Application for Planning Permission for Works or Extension to a Dwelling

Development: Demolition of existing single garage and construction of new side extension
Location: 33 Merryfield Crescent Angmering BN16 4DA

Plans, Elevations and section as Proposed		PHILIP J CLAY ARCHITECTURAL DESIGN	
PROJECT: Garden living room 33 Merryfield Crescent Angmering BN16 4DA		TELEPHONE -01903 815889	
CLIENTS: Mr and Mrs Harris	Scale & plan size 1:50 at A1	DWG. NO. 2341-1 Rev. 142 Nov 24	P. J. Clay Feb 2024

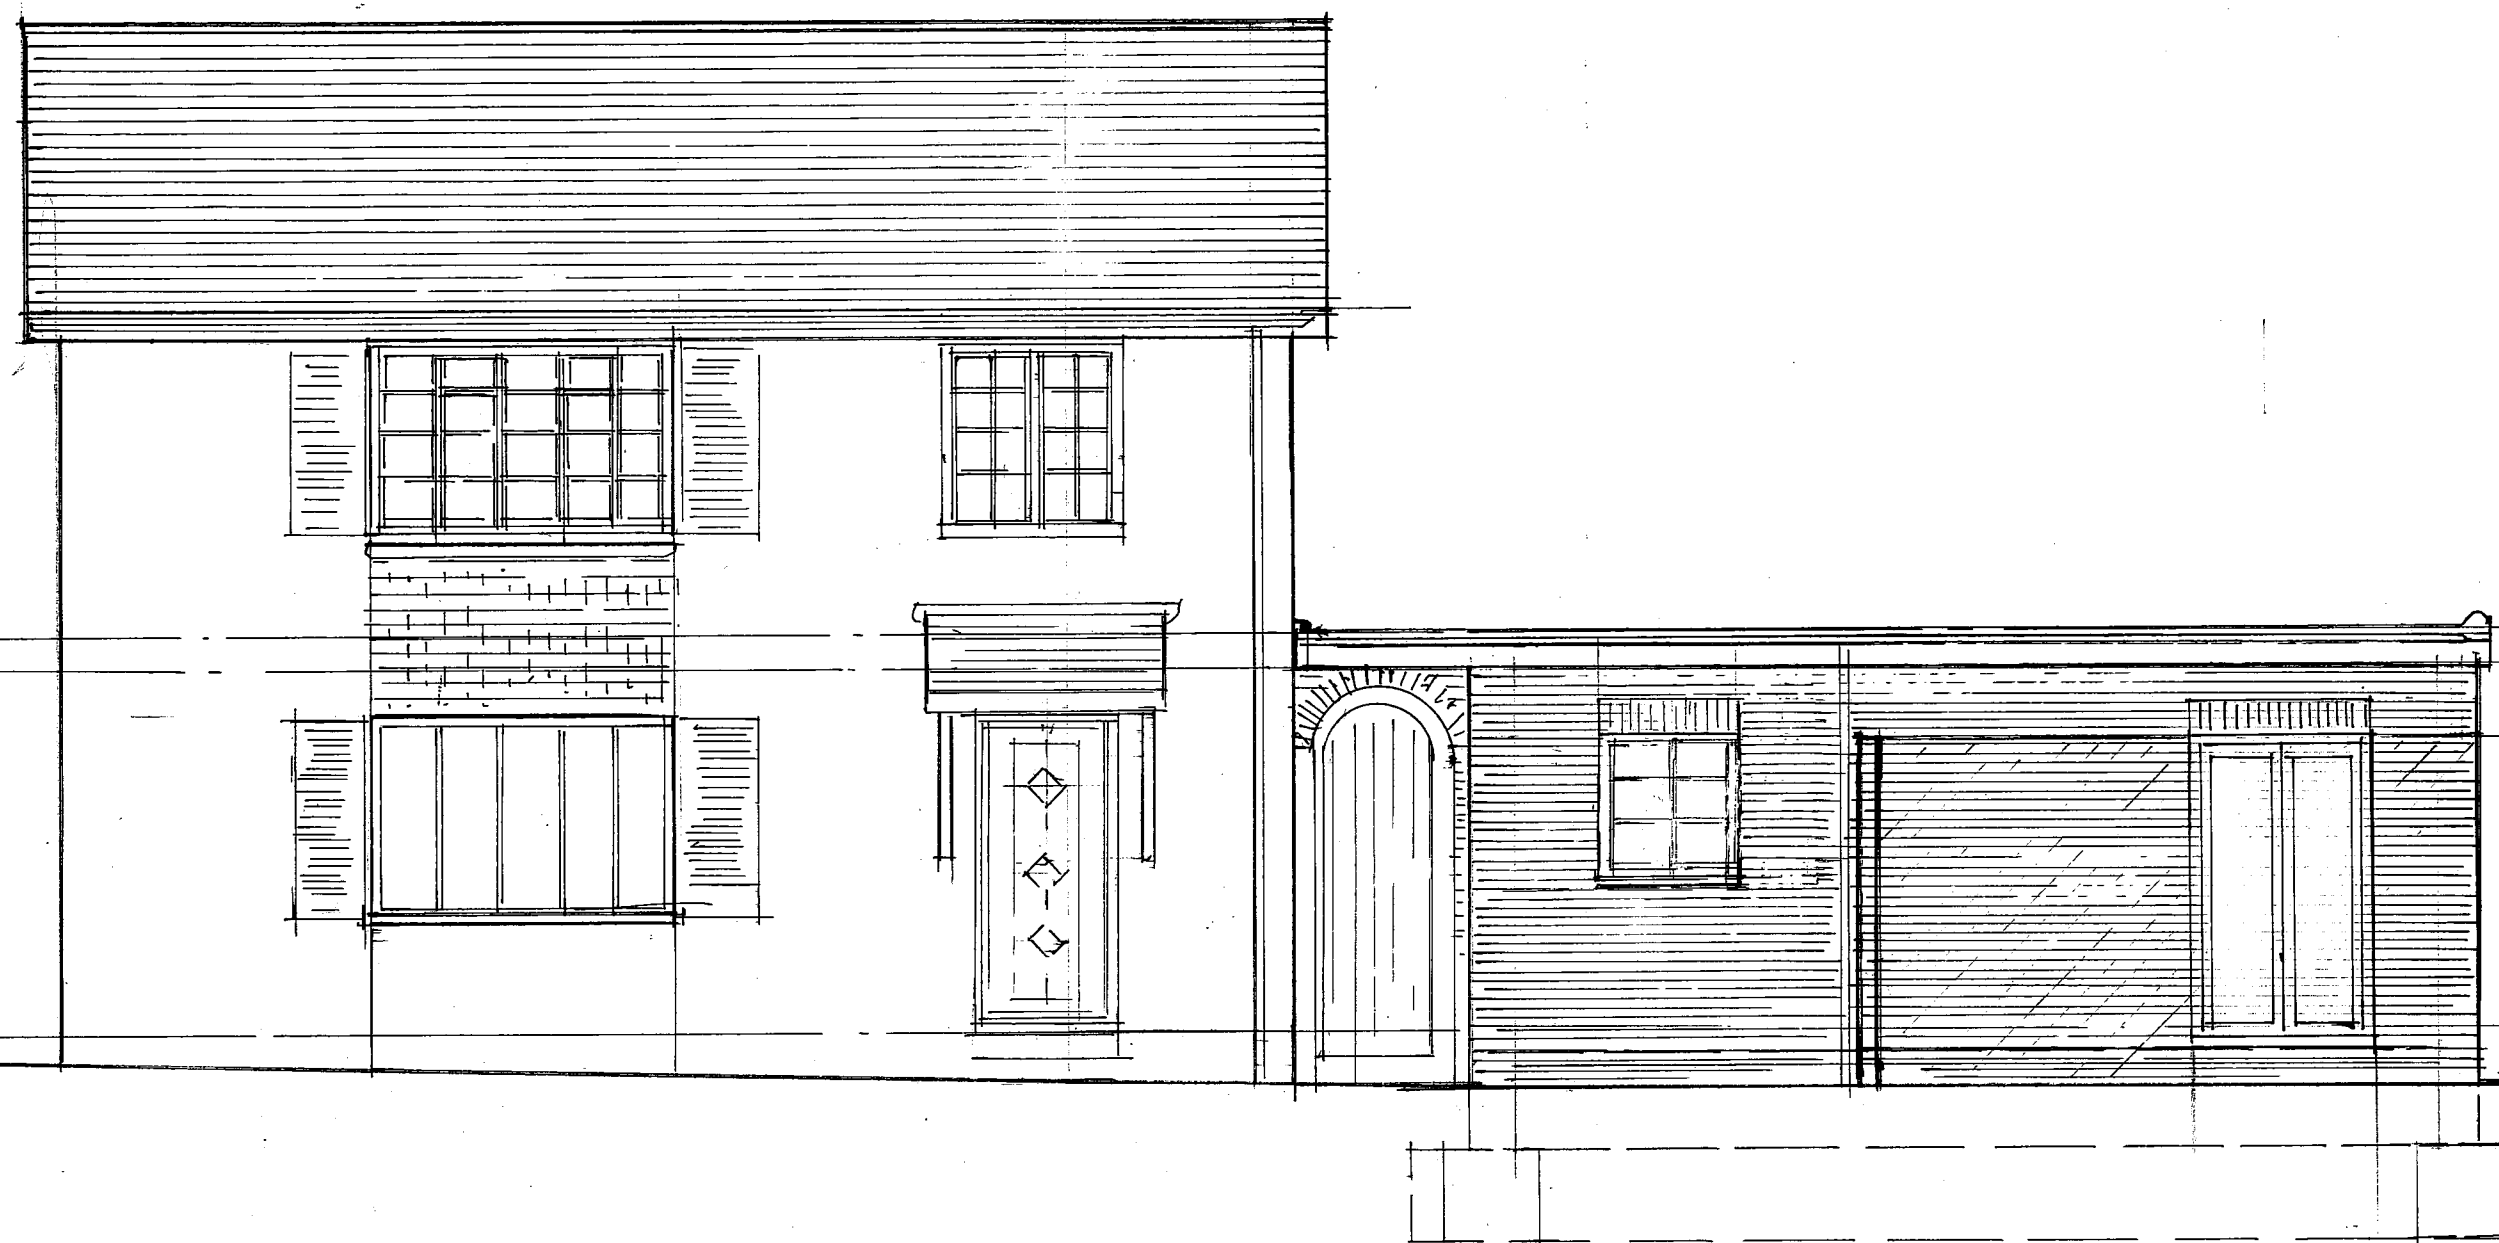
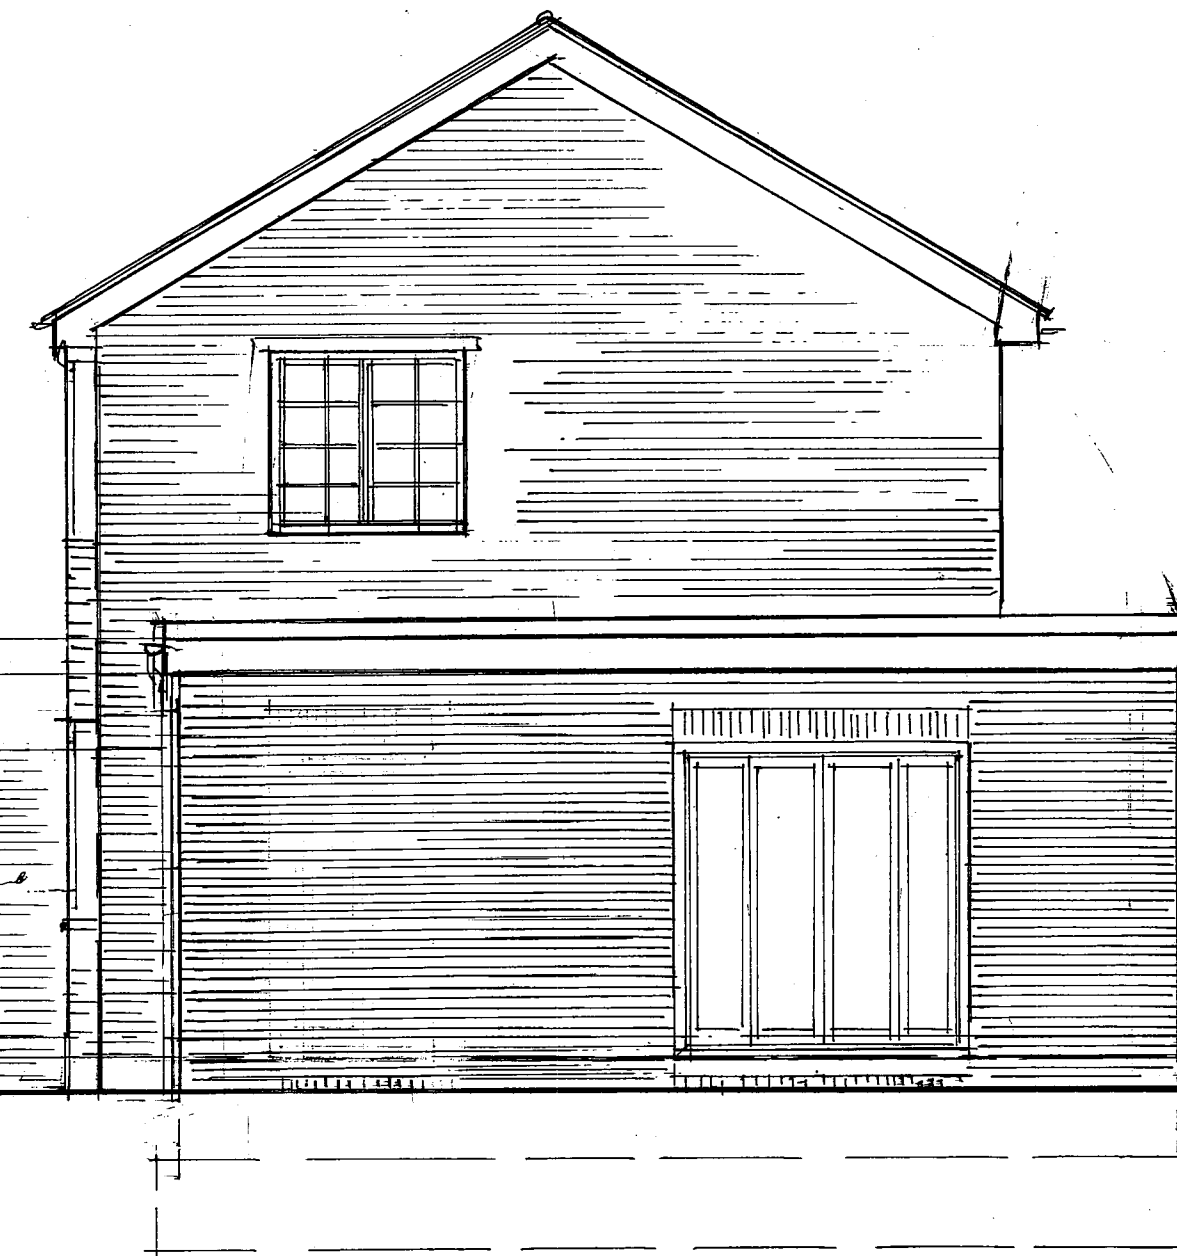
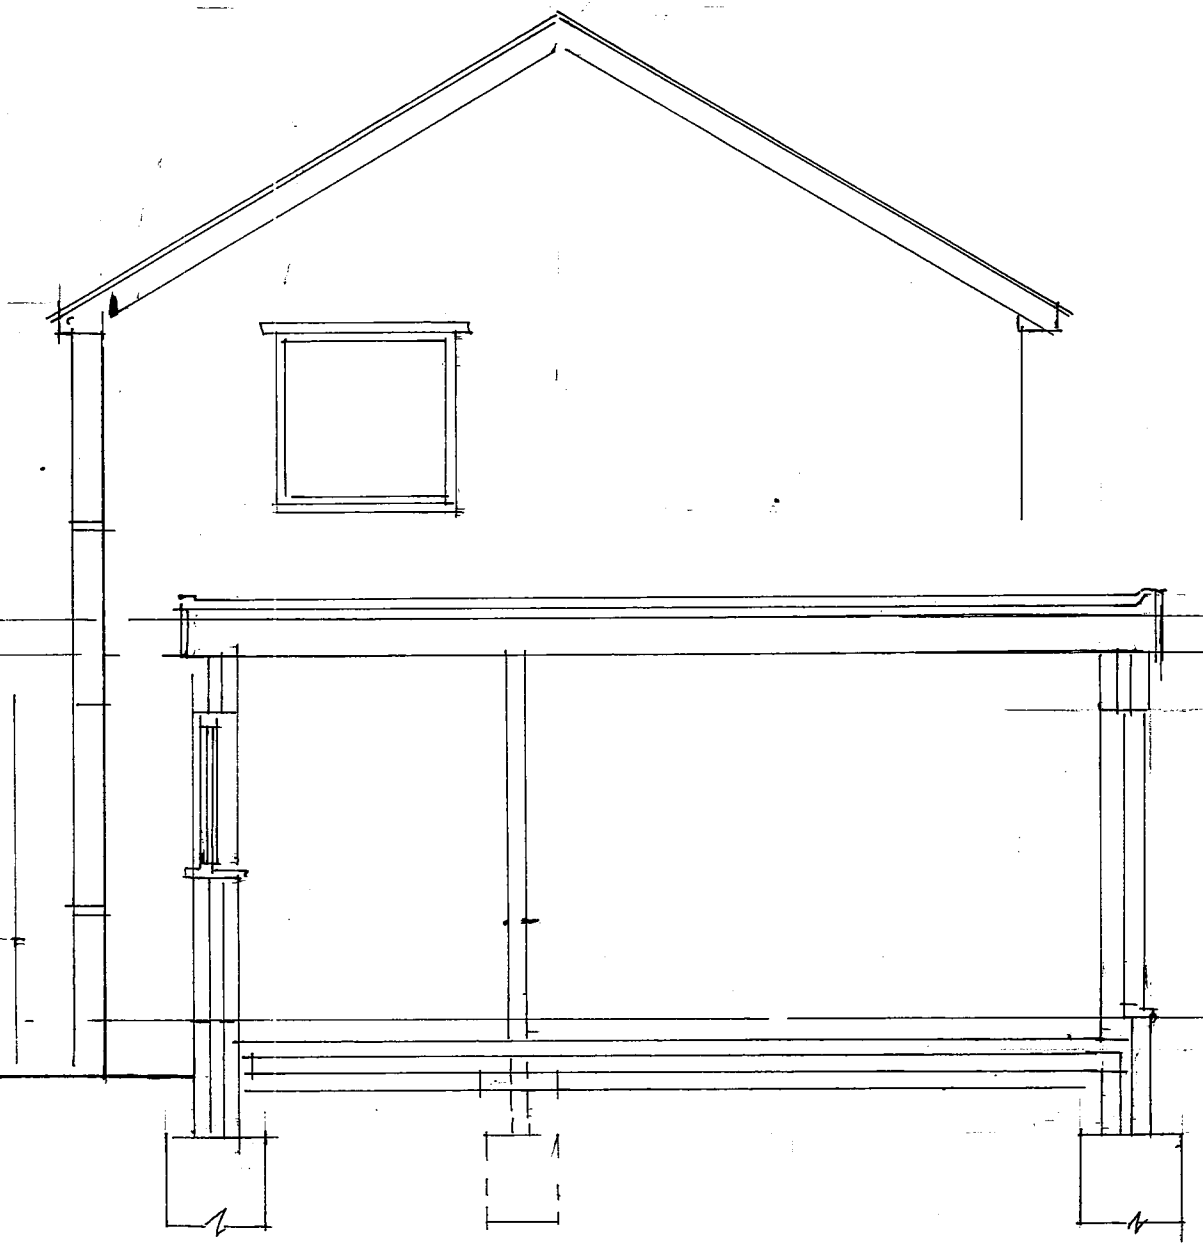
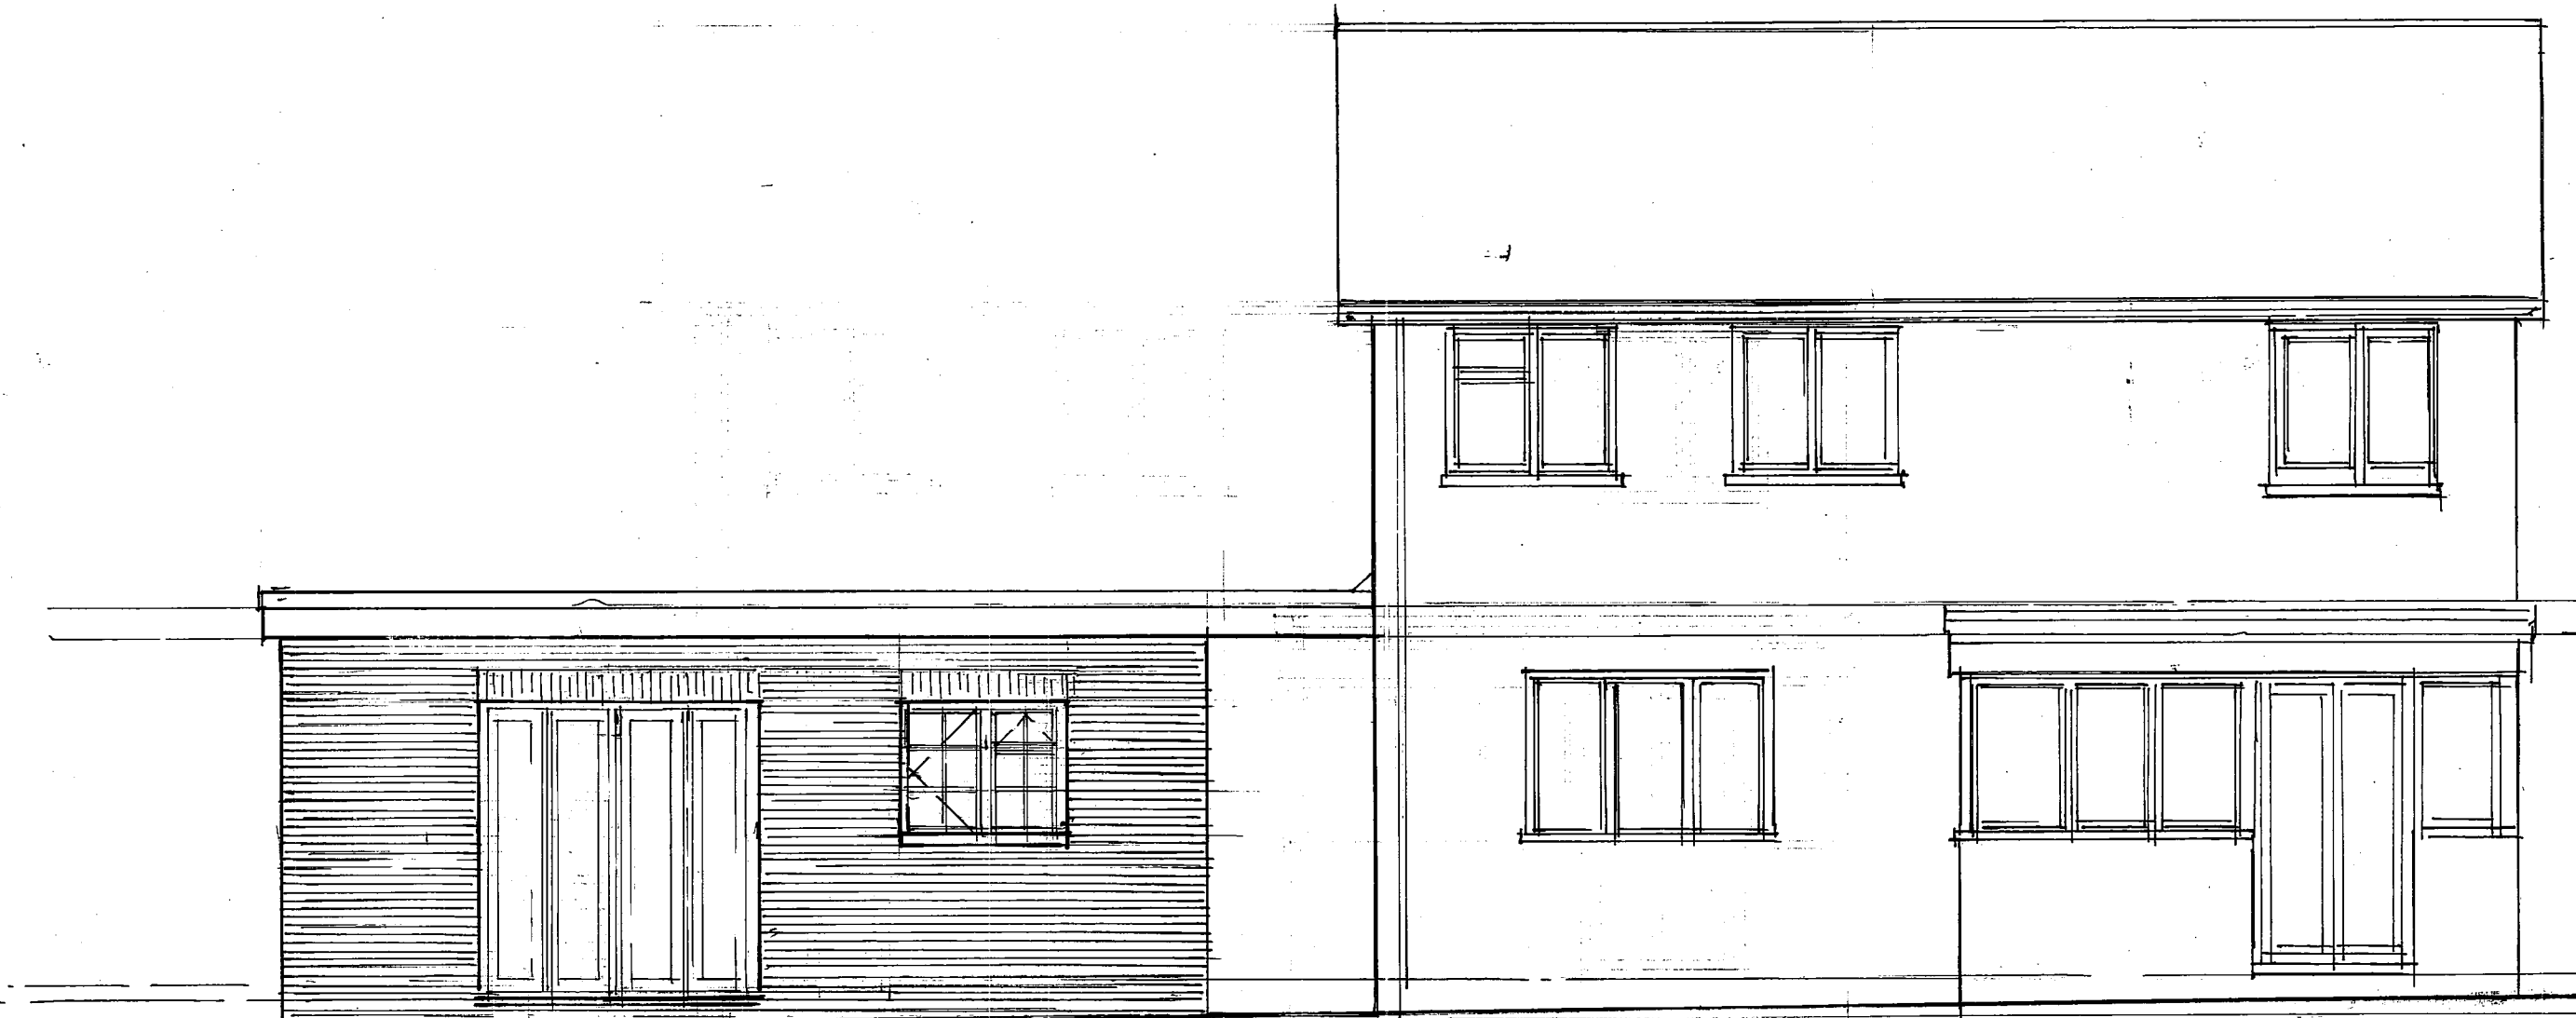
Elevations

The elevations submitted do not measure to scale, please review and amend.

SOUTH ELEVATION

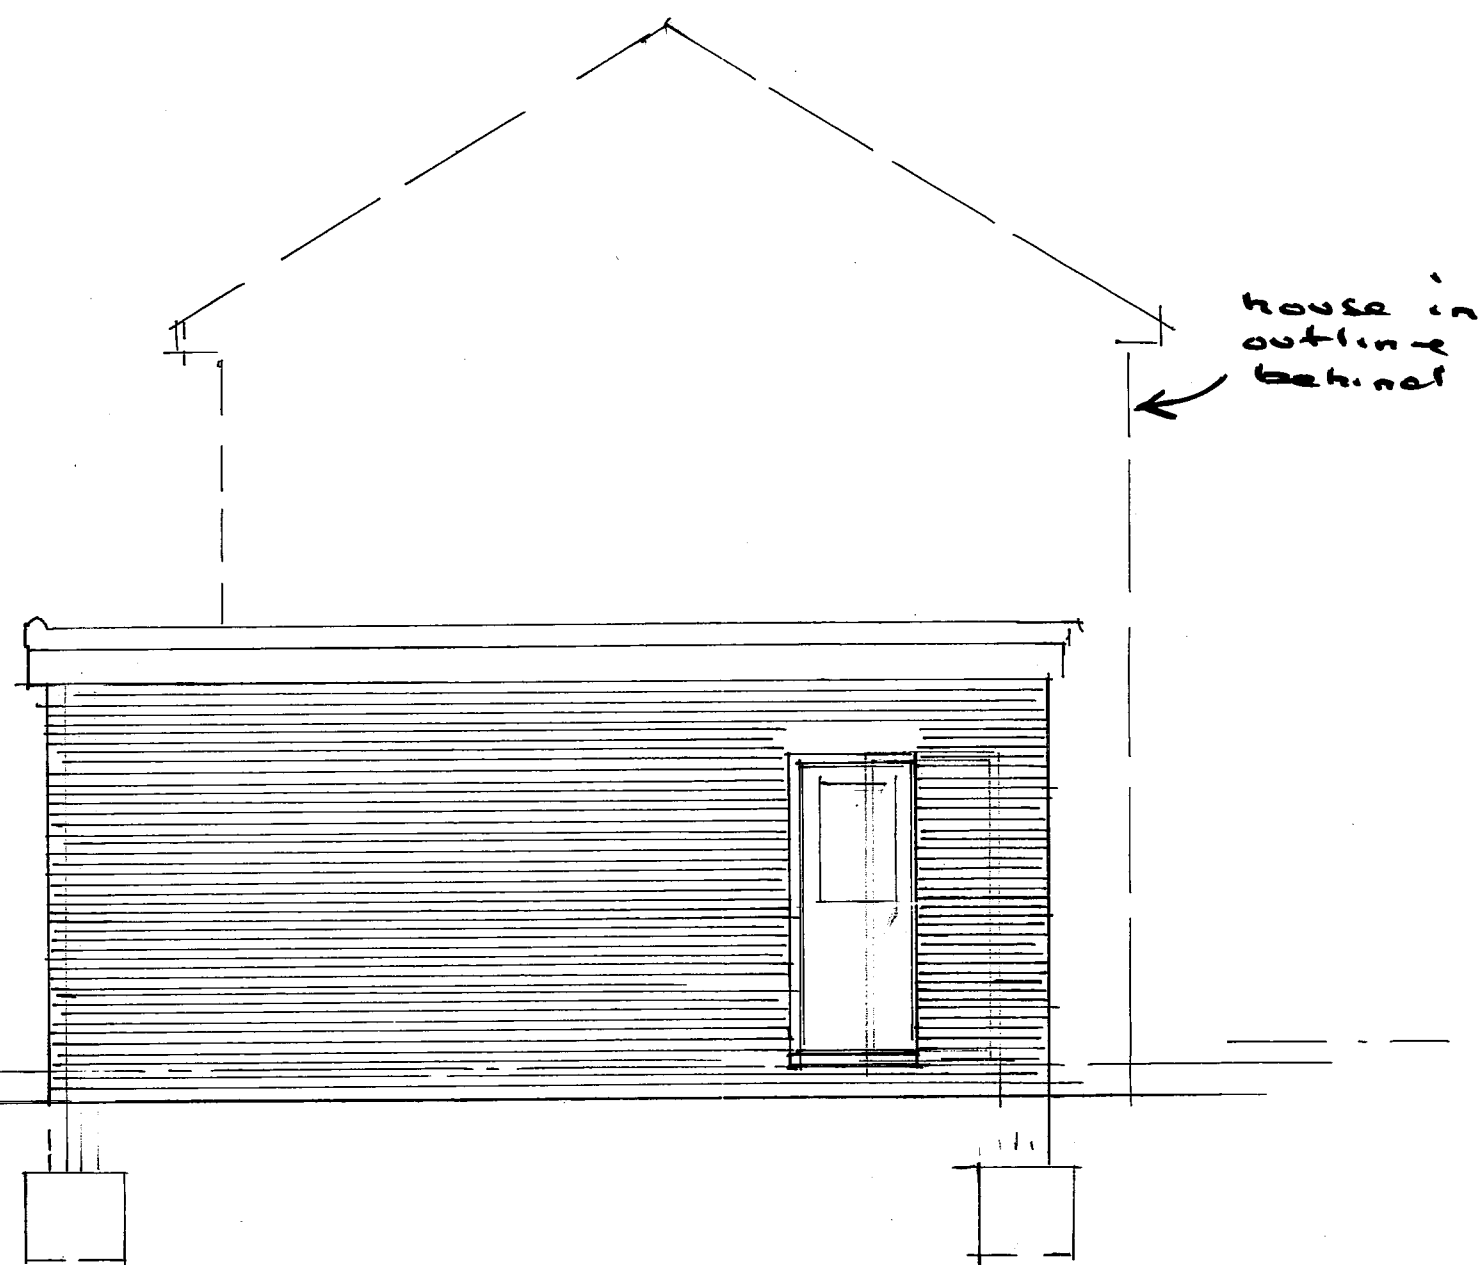
Elevations

The north and south elevations have been mixed up, please review and amend.
